**Consultation Response from Calderdale MBC****2023/92448 Former Cooper Bridge Water Treatment Works, Leeds Road, Mirfield, WF14 0BT****Outline application for erection of B8 industrial unit****Date Responded: 5<sup>th</sup> July 2024****Responding Officer: Kate Peach, Principal Conservation Officer****Responding Ref:**

SITE PLAN

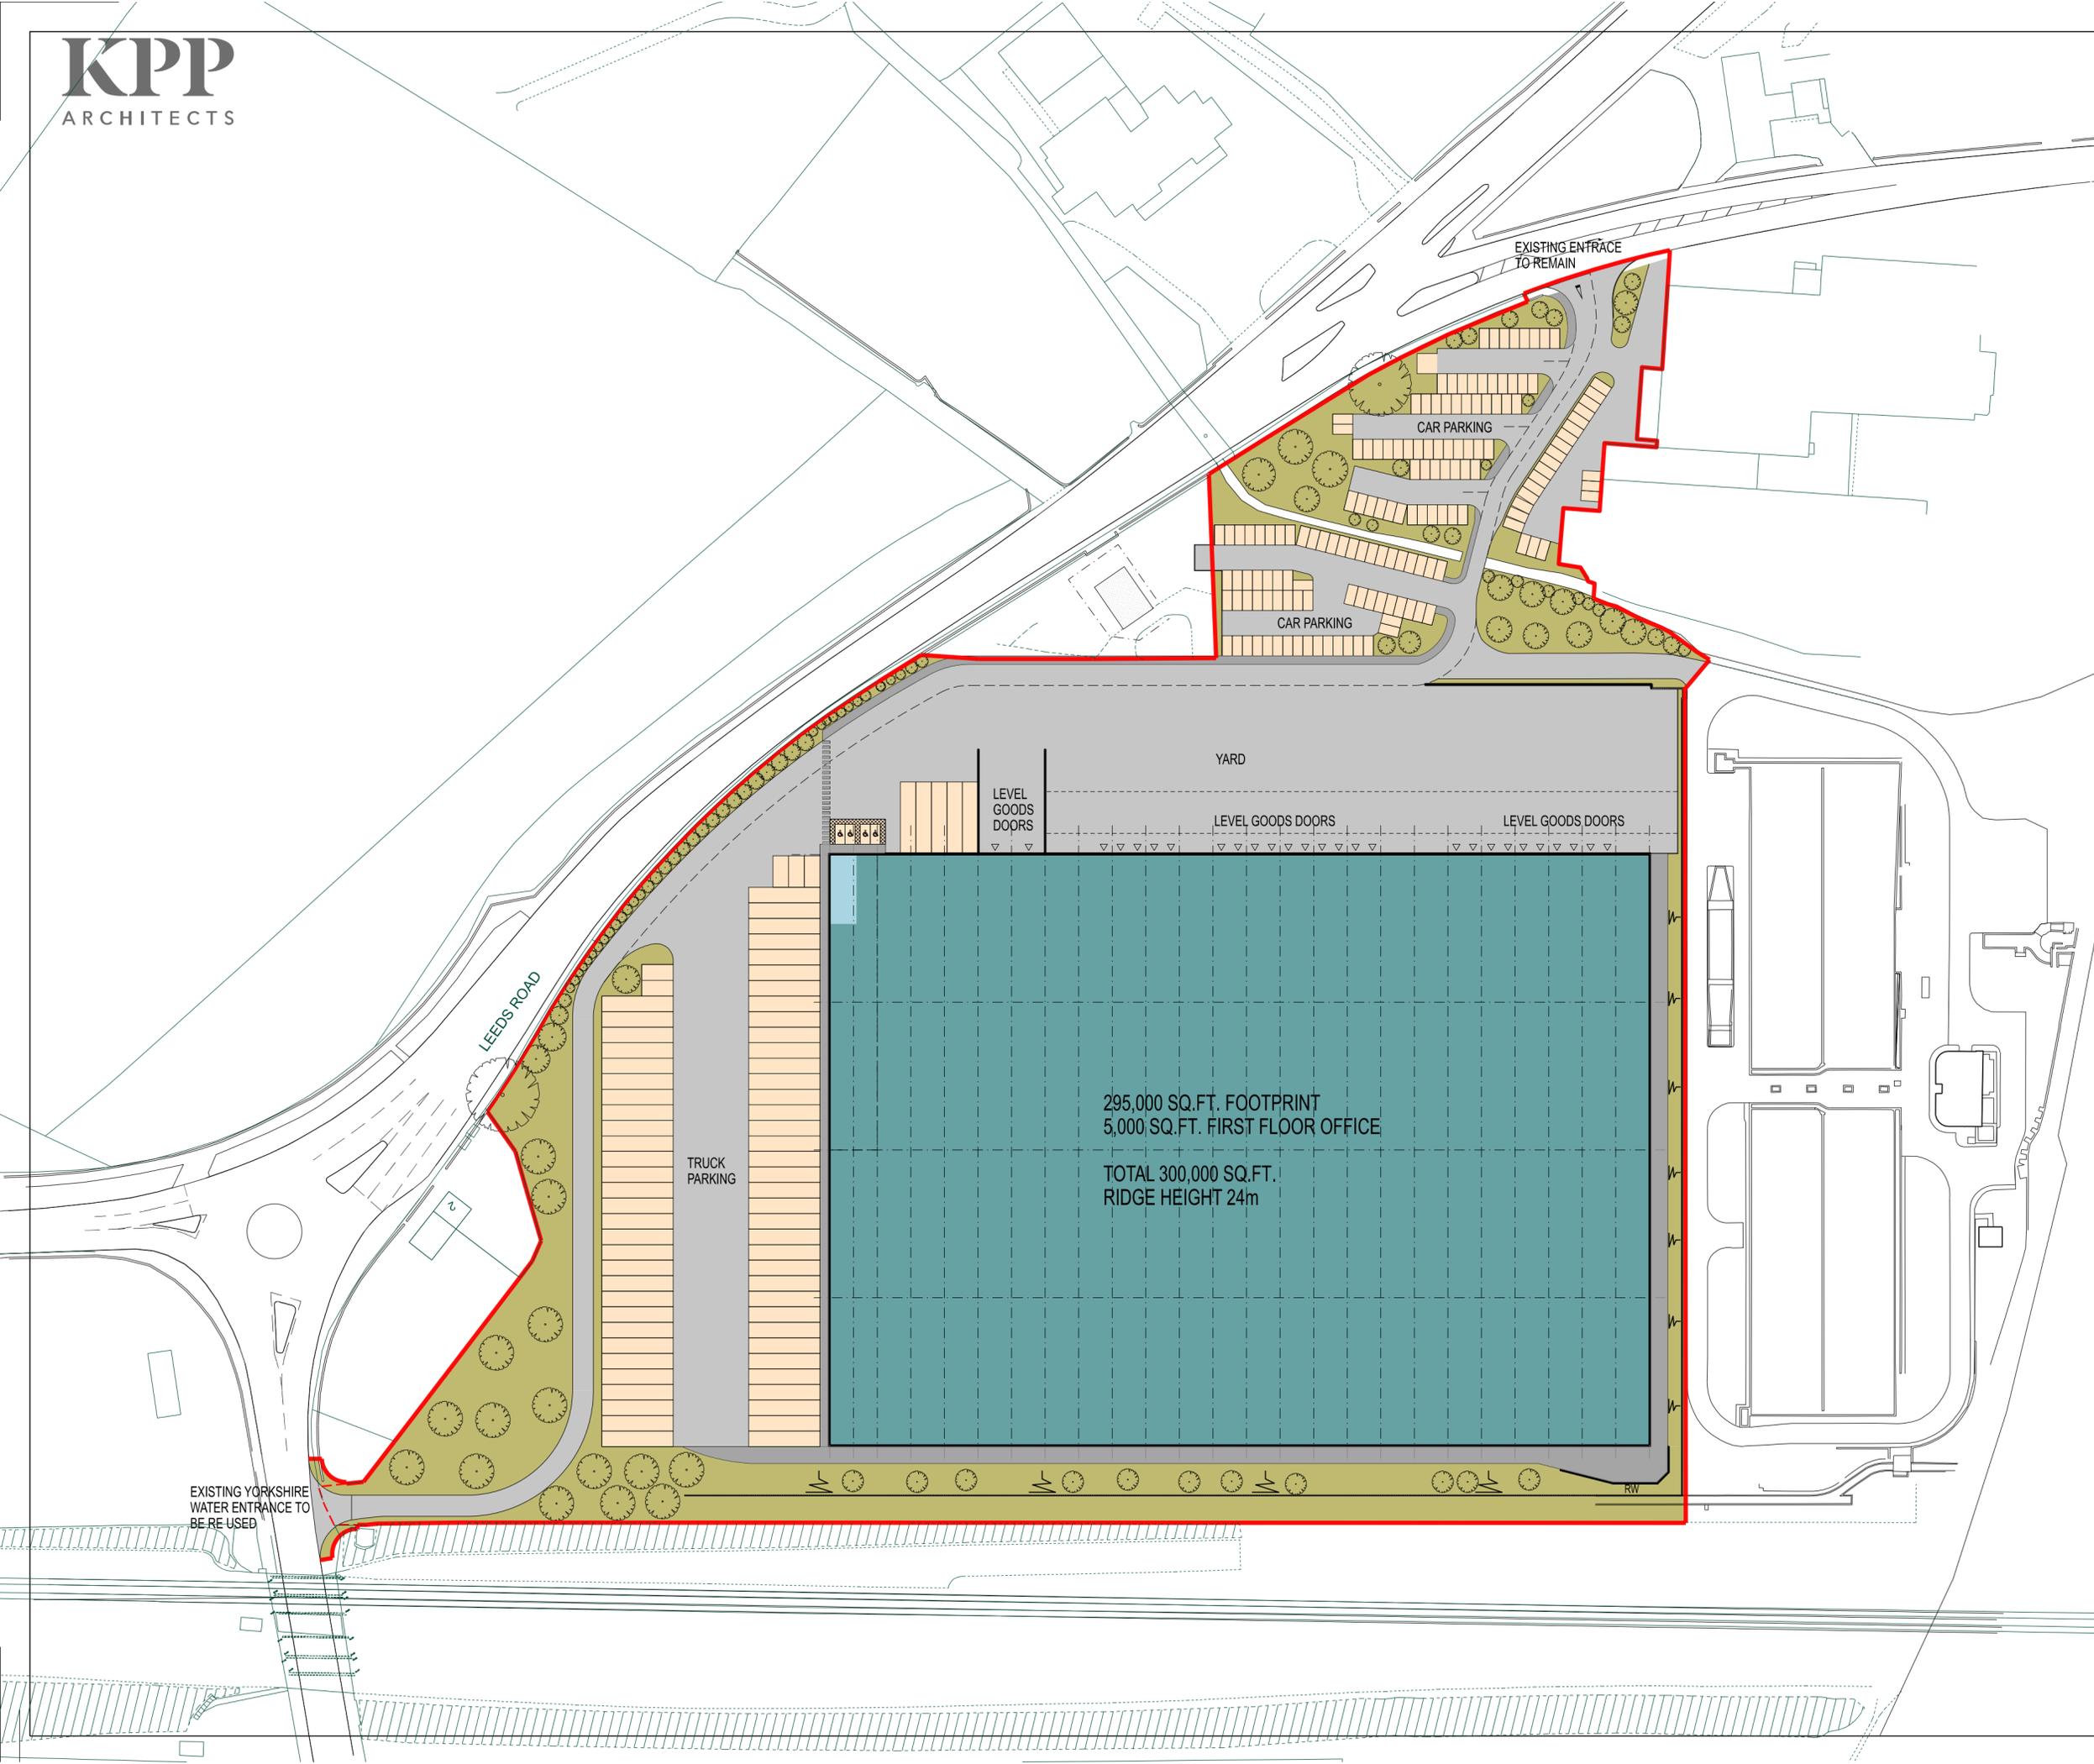
It is noted also that the Site Plan and the Parameters Plan includes reference to a building height or ridge height of 24 metres. Other documents refer to a warehouse, and indicative plans suggest the site would be developed for one large building of this potential height rather than broken up into smaller blocks. Whilst it is appreciated that the site was previously occupied by a water treatment works, it is understood that the built form at that time was generally low rise with 2m high tanks and walls. Clearly a development of the indicative height now proposed would represent a substantial increase in the height of the built form on the site, with large bulk and massing. Thus it is considered that there is potential for there to be harm to the significances of the heritage assets referenced above by virtue of development within their settings particularly in terms of longer distance views.
